Town and Country Planning Act 1990
Section 78 Planning Appeal

London Borough of Hillingdon Appeal Statement

Proposal:
Change of use from C4 house in multiple occupancy (HMO) to sui generis HMO for 7 bed
and 7 persons with no external alterations.

Our Ref: 27994/APP/2021/3581

ANNEX - R/O 14 DEVON WAY

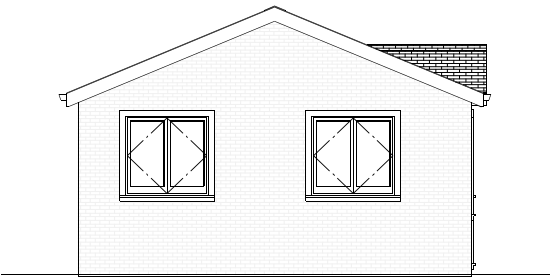
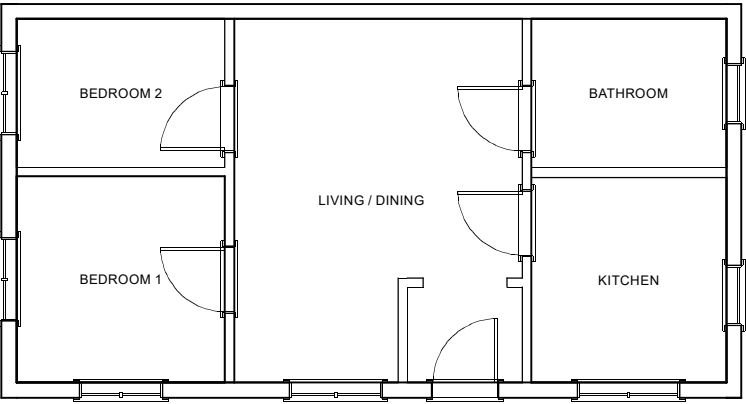
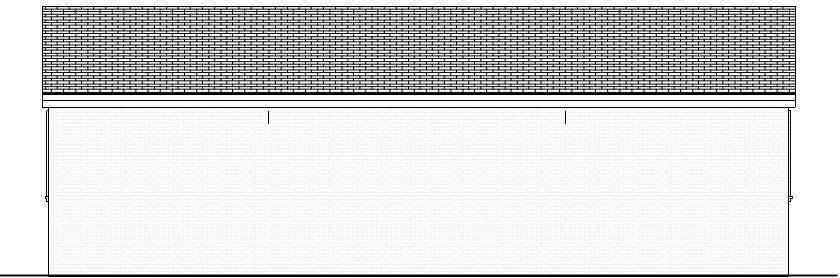
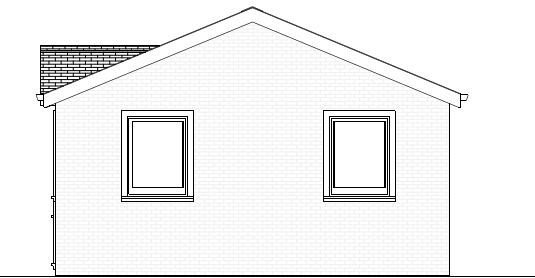
- 1.2 As stated in the delegated report, material external alterations have been carried out to the wooden outbuilding to the front of the site and to the rear. Also, the rear outbuilding is being used as a self-contained residential unit. These developments are associated to the use of the property as an HMO have therefore been considered as part of the planning assessment.

4. By reason of its poor levels of outlook, the existing outbuilding (which is being used as self-contained residential unit), has resulted in a substandard form of internal living accommodation to the detriment of the amenity of its occupiers. The proposal, therefore, conflicts, with Policy DMHB 16 of the Hillingdon Local Plan: Part 2 - Development Management Policies (2020), Policy D6 of the London Plan (2021) and the National Planning Policy Framework (2021).

5. The existing outbuilding (which is being used as a self-contained residential unit) has no private useable amenity space provision, and has therefore resulted in a substandard form of external living accommodation to the detriment of the amenity of its occupiers.

- 2.1 The Appellant's Statement argues that the outbuilding does not form part of the Appeal proposal and should therefore not be considered. However, the Council does not share this stance. Notably, during the planning officer site visitation, it was observed that the outbuilding was inhabited by an individual and his young family, tasked with managing the HMO at the site and other HMOs owned by the applicant (refer to Appendix B for photographic evidence). Such utilisation is intrinsically tied to the main property's function as an HMO. Consequently, it becomes prudent to assess the planning implied of the outbuilding's use as a self-contained residential unit.

- 2.2 The Appellant claims that the self-contained use of the outbuilding is lawful. However, this assertion is not correct. A lawful development certificate was granted for the use of the outbuilding as a 'granny annexe' under application reference 27994/APP/2018/3264. However, this was on the basis that the granny annexe being used incidental to the main host dwelling. It is clear from the Appeal proposal that the outbuilding is being used as a self-contained residential unit, meaning that its current use is no longer covered by the previously lawful development certificate.
